**Fwd: Holiday Inn building permit 2017-01240 conditions**

Subject: Holiday Inn building permit 2017-01240 conditions

On our permit for the Holiday Inn (permit number 2017-01240) Glenn Harmon listed a condition (#4) that *Guardrails are required for hatches and mechanical equipment on a roof within 10' of the edge per IBC 1013.5 where the existing parapet is less than 42" high*. The contractor has asked if they can permanently install a lifeline system complying with ANSI 359.1. There is no exception under the 2009 code for this, however under IBC 2015 1015.6 which has since been adopted, there is an exception that guards are not required where such a system is installed. Is it acceptable to install this lifeline system in lieu of the guardrail system?

1 ROOF PLAN
 FP1 SCALE: 1/16" = 1'-0"

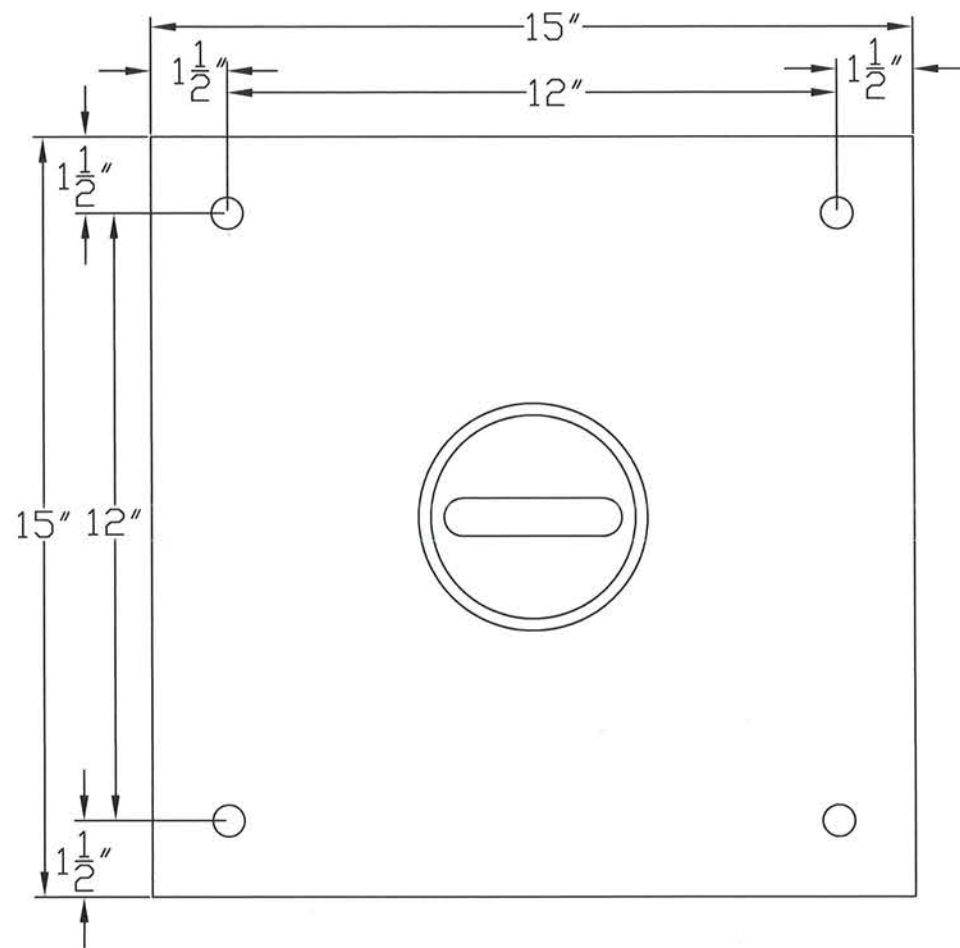
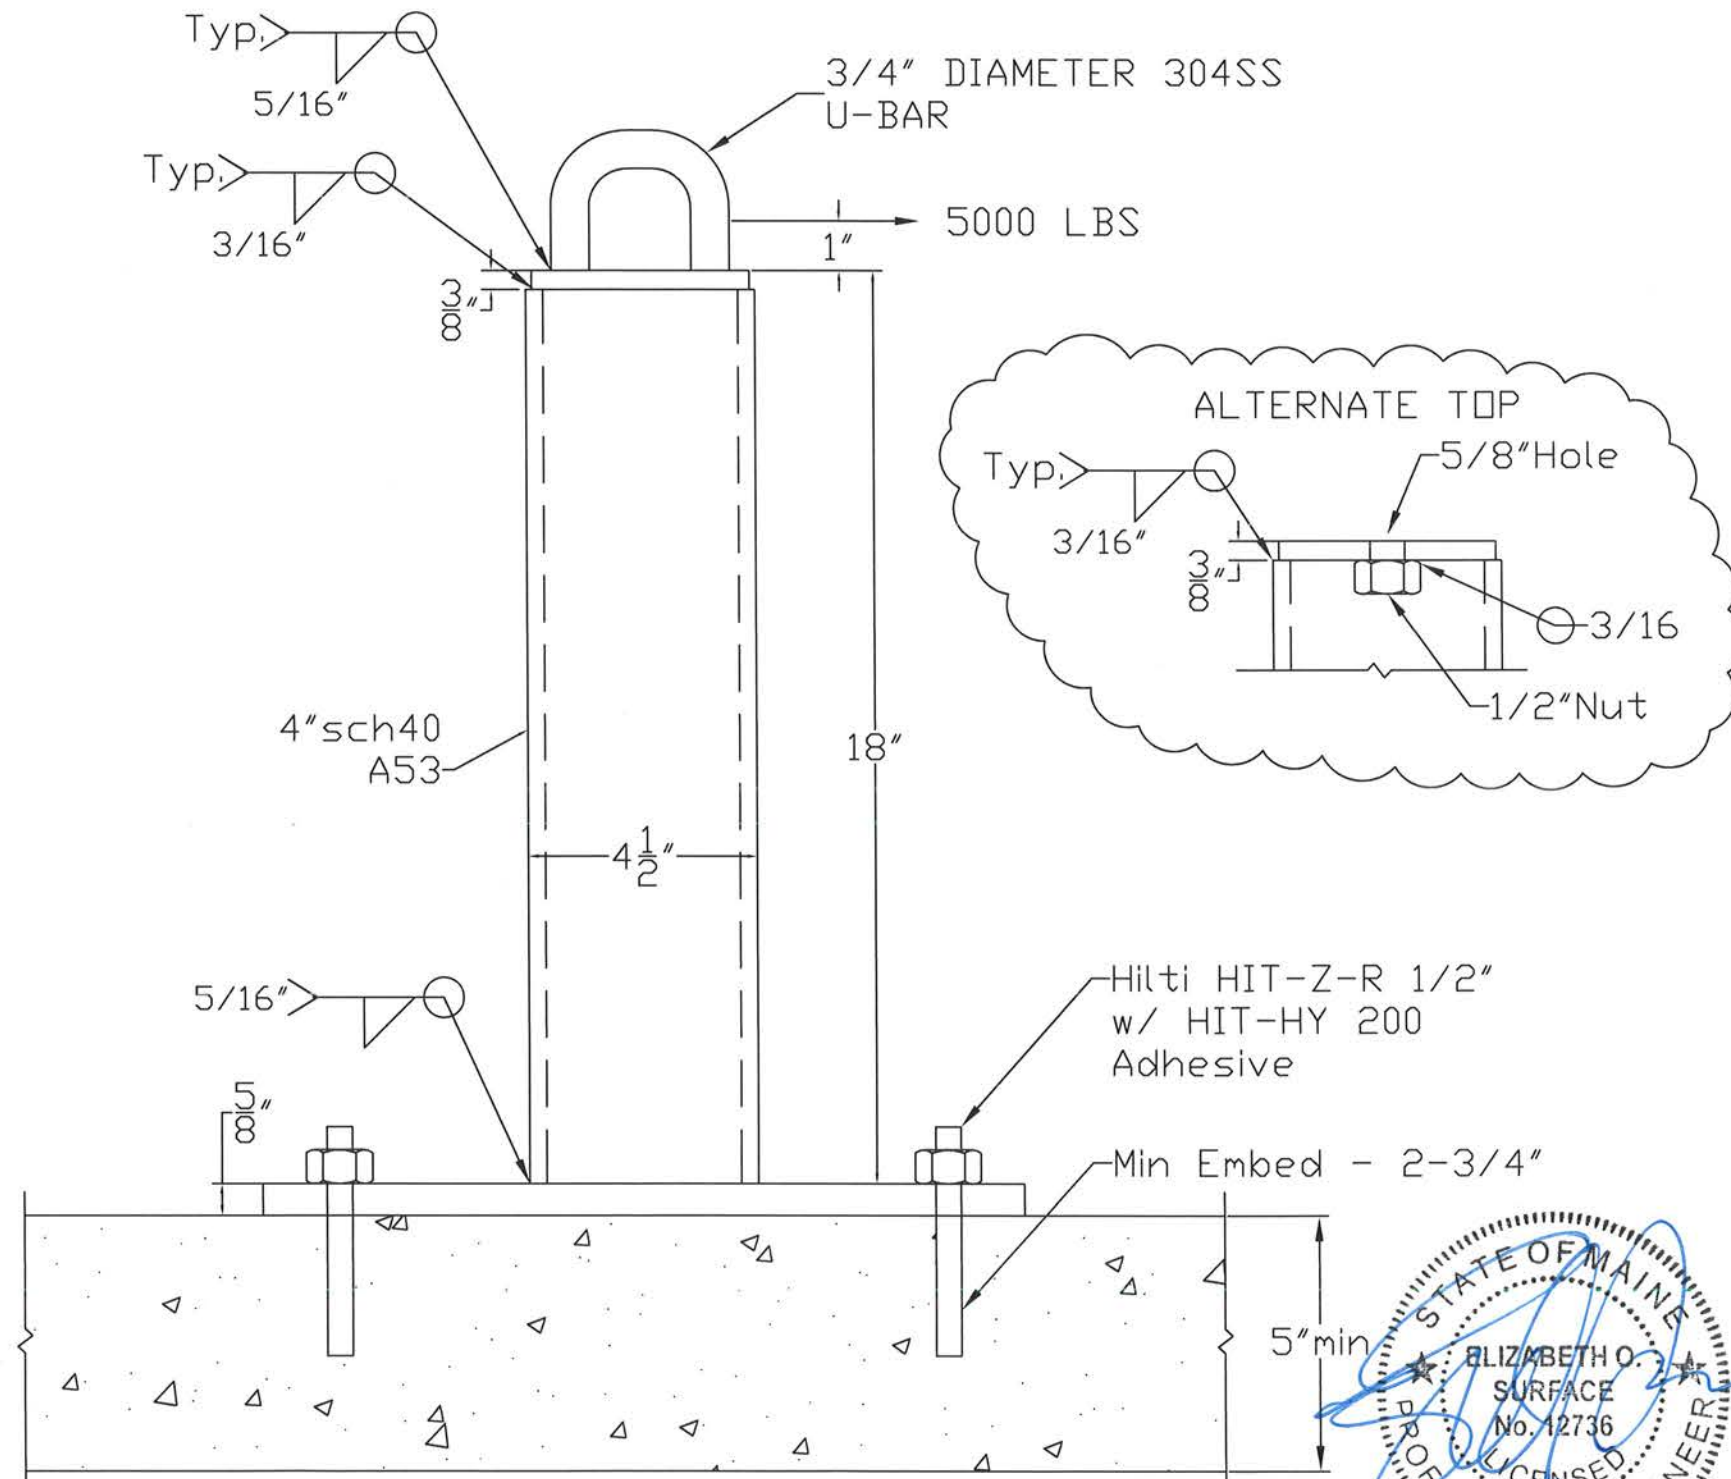
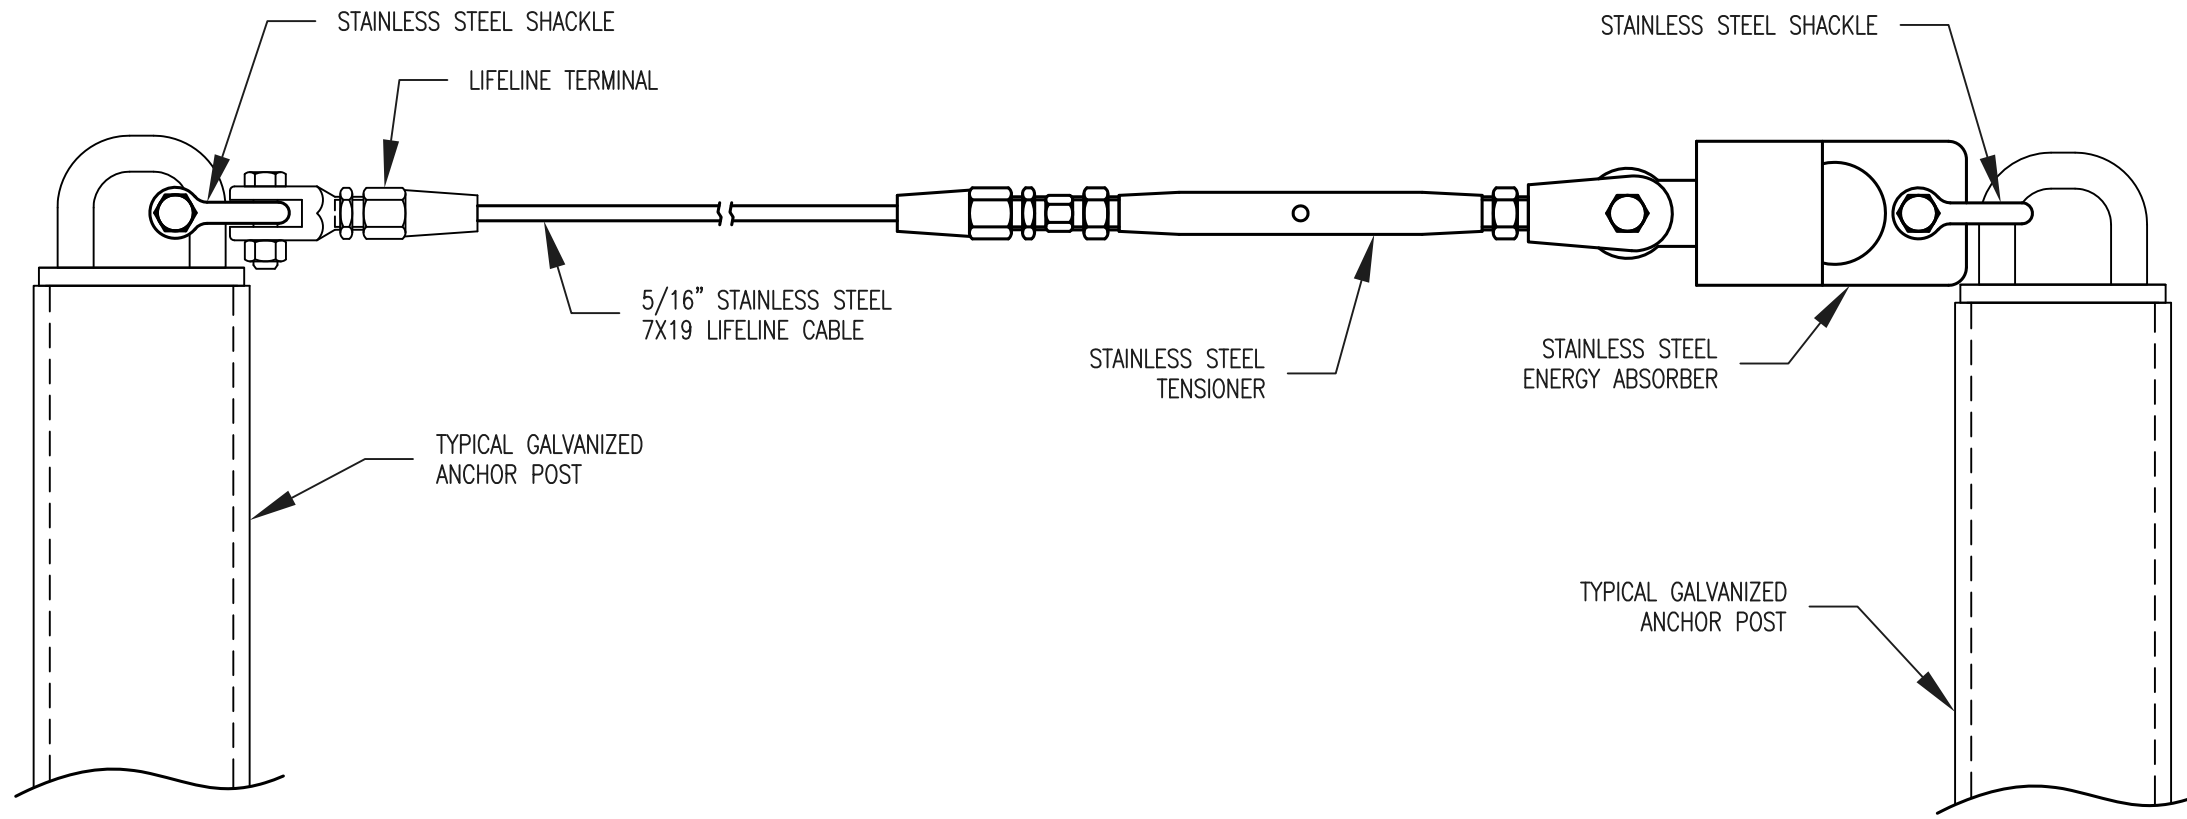
I reviewed this information and find it acceptable as an alternative to the guardrail system, with the following conditions per the letter from engineer Matthew J. Miller:

1. The anchor embedment into the existing roof concrete be increased from 2-3/4" to 3-3/4" depth.
2. The engineer shall verify the condition of the concrete substrate prior to the installation of the roof anchor plates.
